*Sizewell C (SZC)*

Planning Inspectorate Reference: *EN010012*

*Deadline 2 – 2 June 2021*

ESC comments on any additional information /  
submissions received at Deadline 1

DRAWING TITLE:
 CROSS SECTION THROUGH THE SSSI
 CROSSING CULVERT

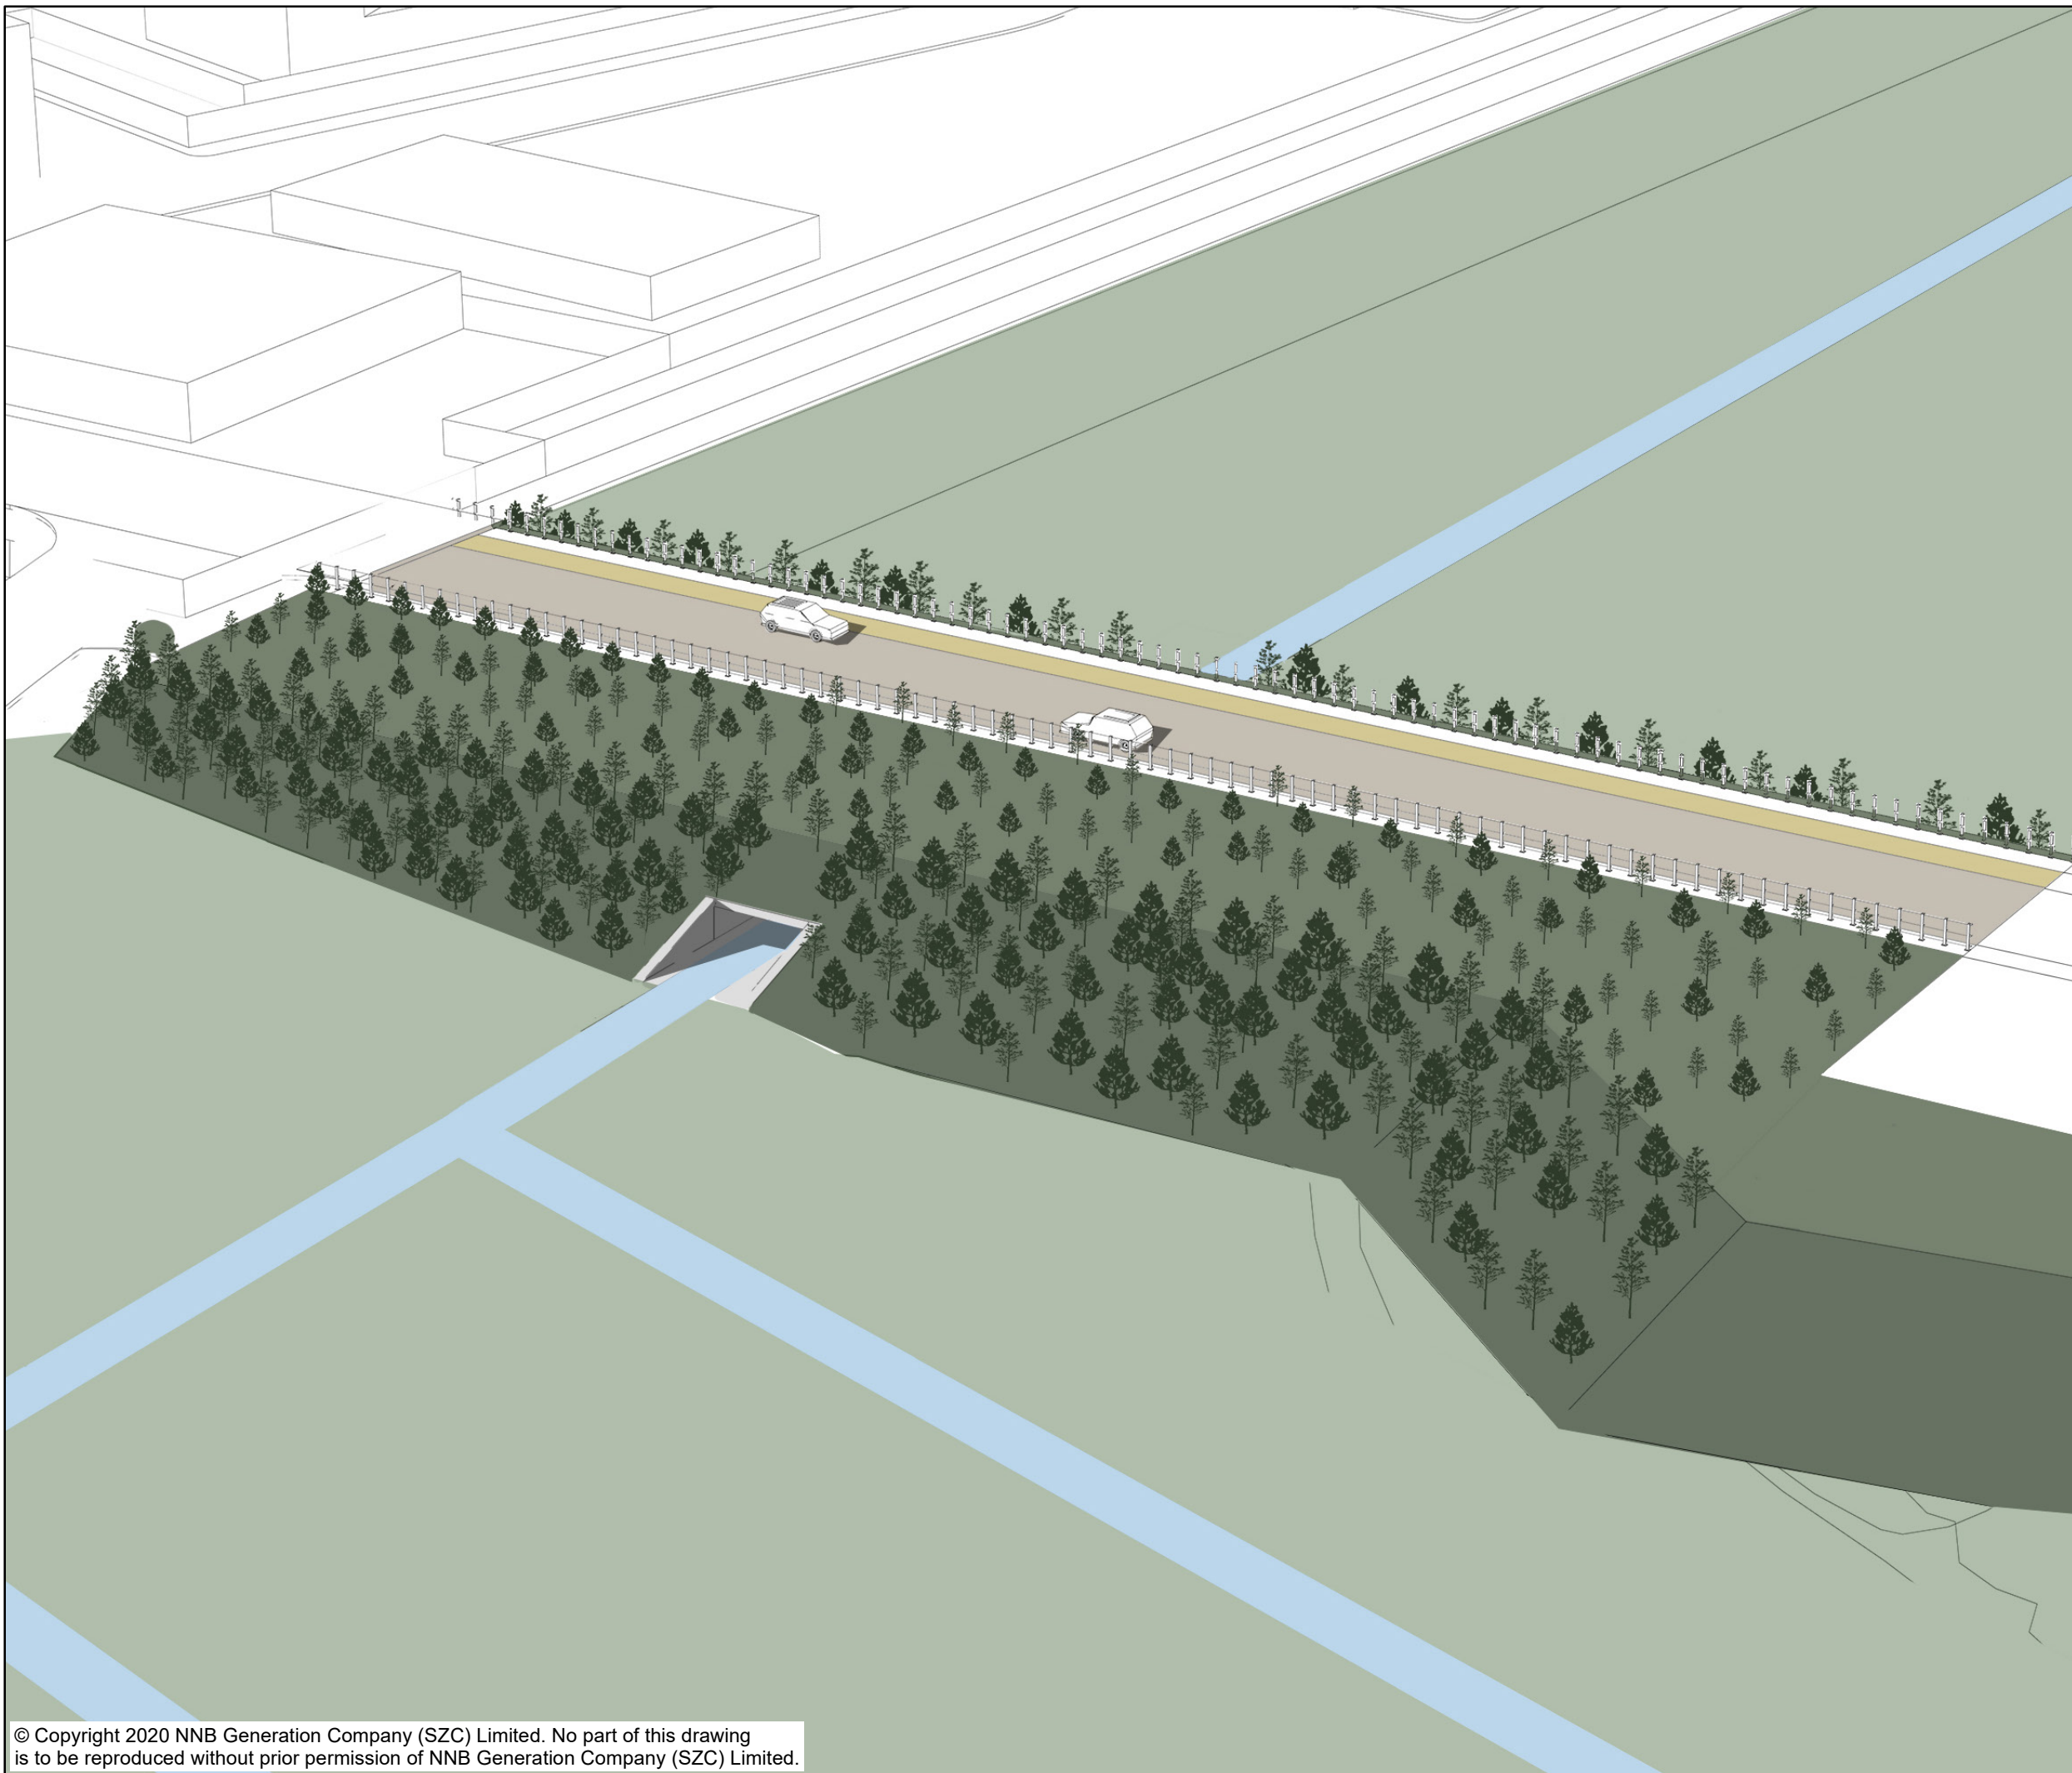
Table 4.6 (Terrestrial Mammals) – Otter – Monitoring of the use of the SSSI Crossing and Lovers Lane culvert by otter must be undertaken more often during the construction phase than in years 1, 5 and 10 as currently proposed in the TEMMP. Monitoring should be undertaken at points throughout the year, during every year of the construction period.

DRAWING TITLE:
 ALDHURST FARM HABITAT CREATION

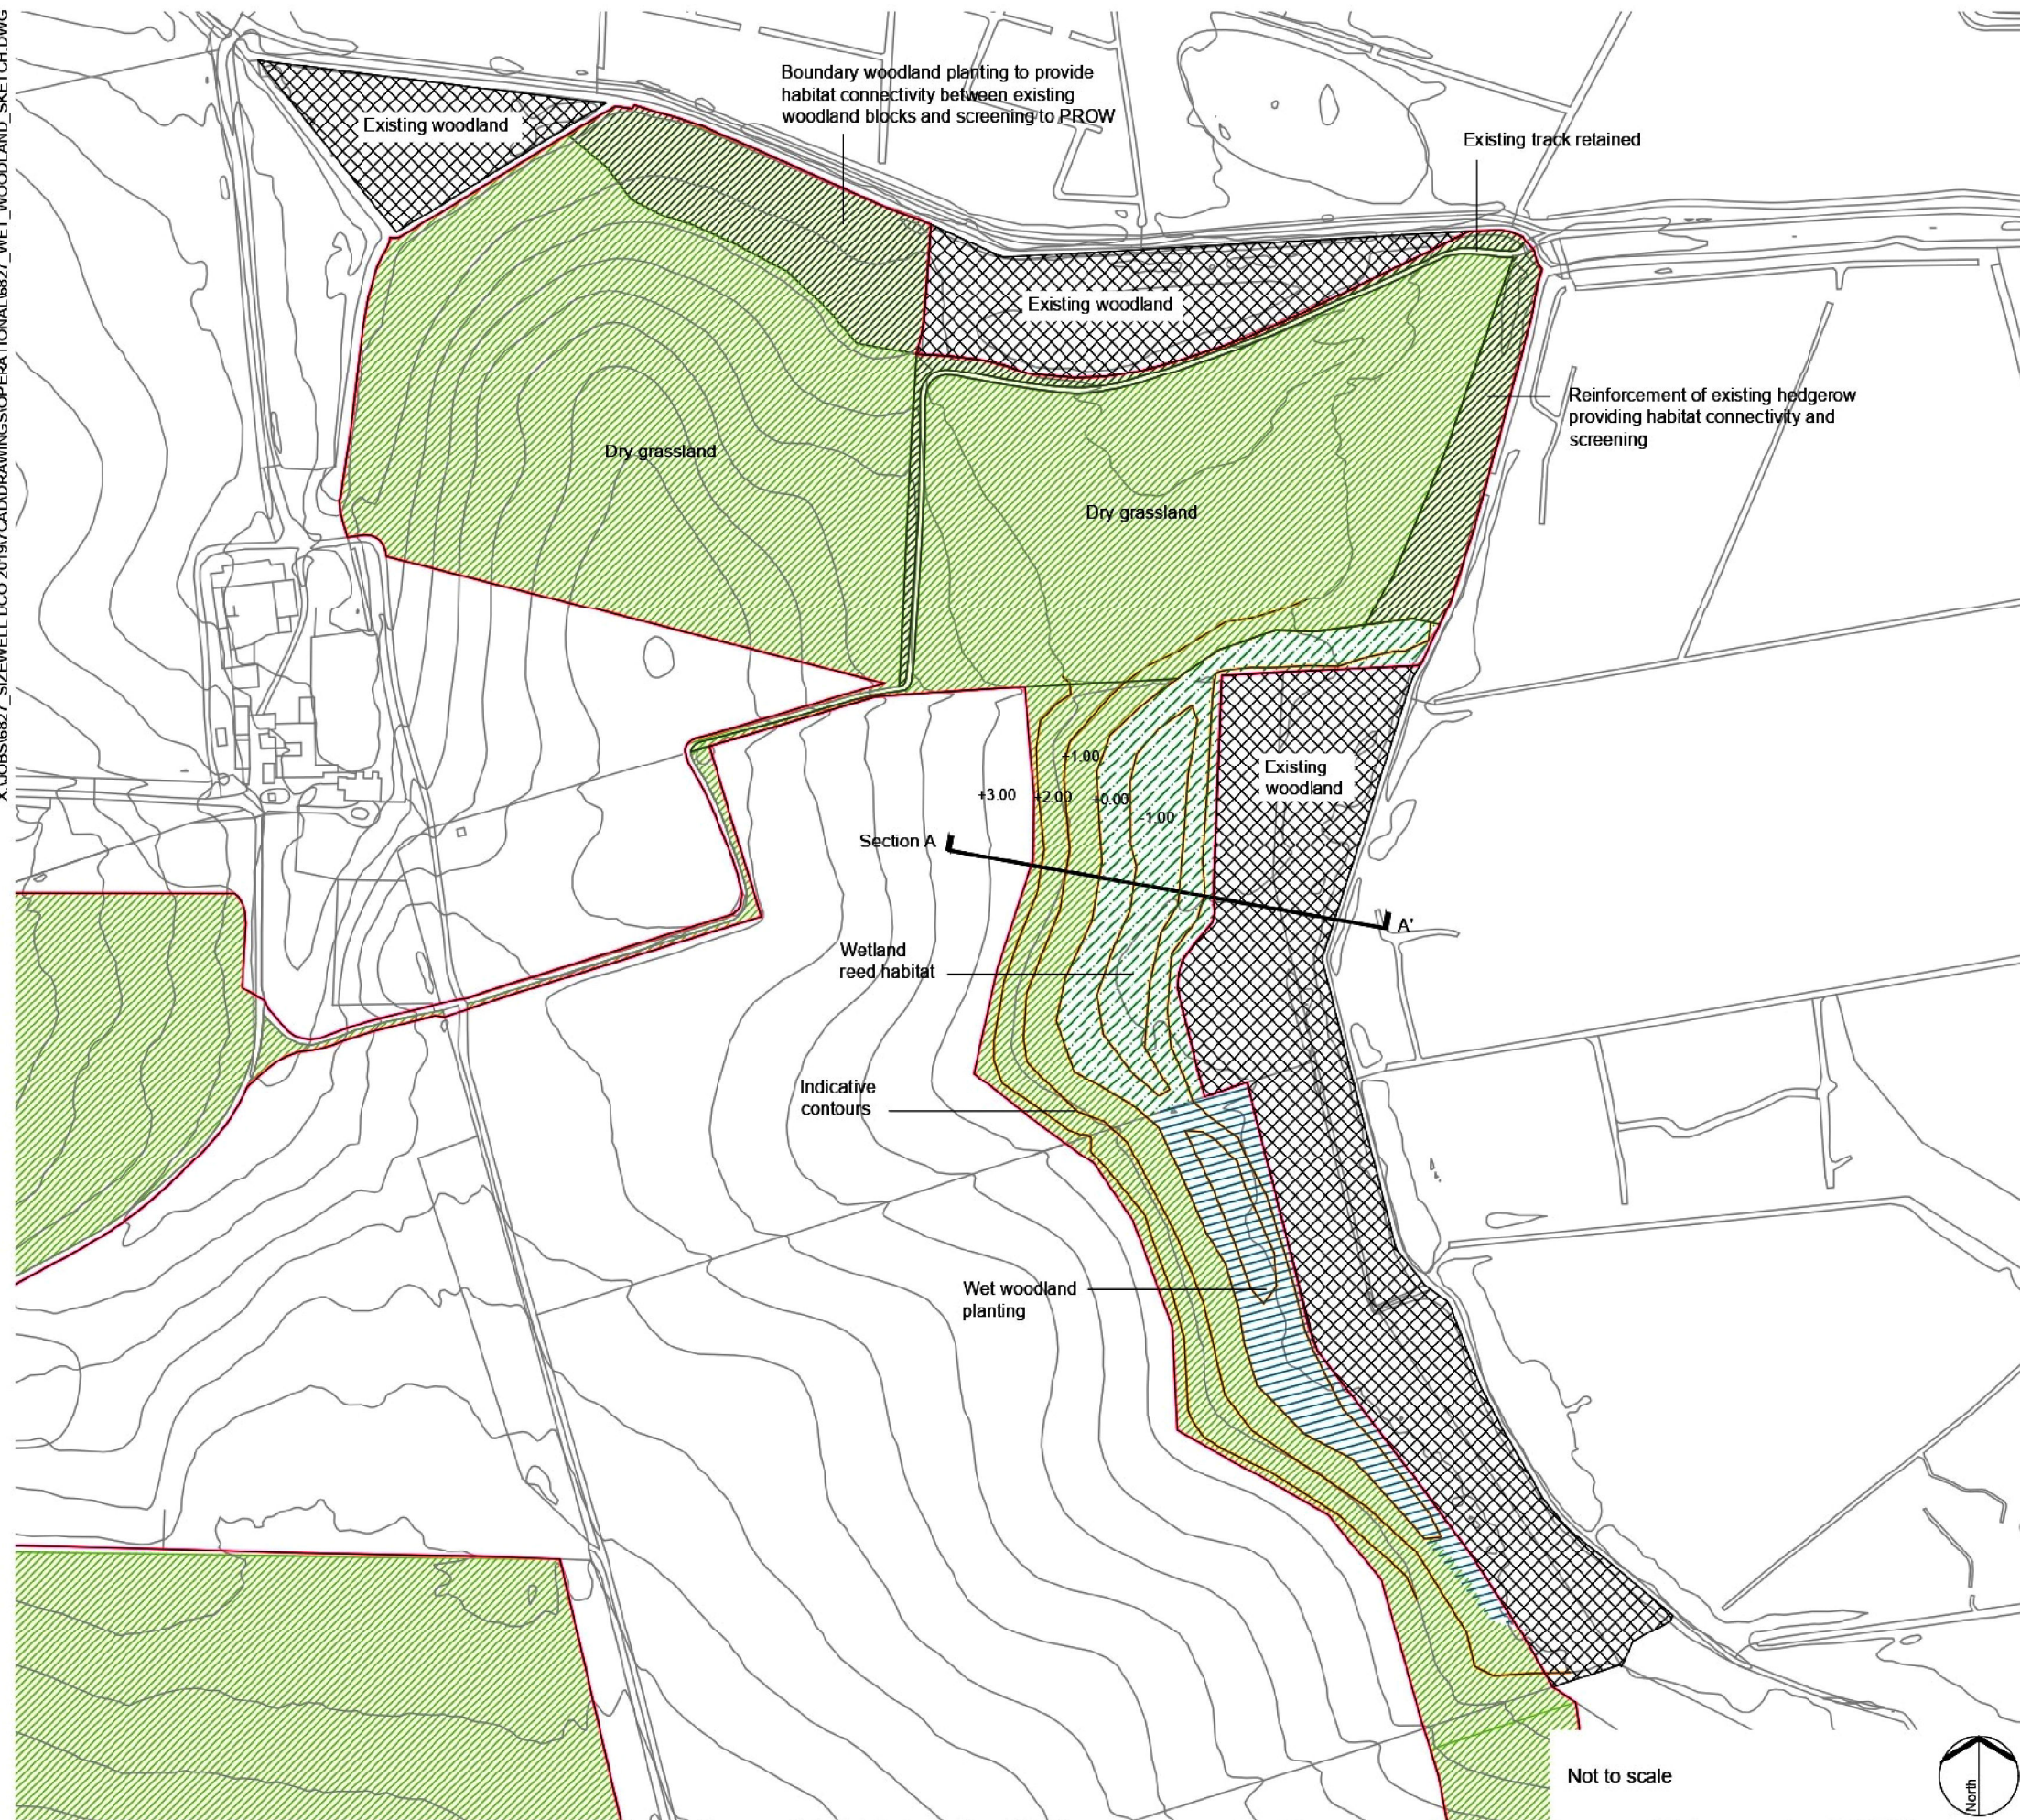
Table 4.6 (Terrestrial Mammals) – Water Vole – Aldhurst Farm is listed as a potential water vole translocation site if population numbers at the time of the commencement of works indicate that it is required. It is understood that one of the wetland basins at Aldhurst Farm is currently fenced to prevent water vole access so that it remains available as a translocation site if it is required. If it is determined that translocation to Aldhurst Farm is not required, then the TEMMP must include a commitment to remove the existing fence as soon as possible after works commencing in order to make this basin available for natural colonisation.
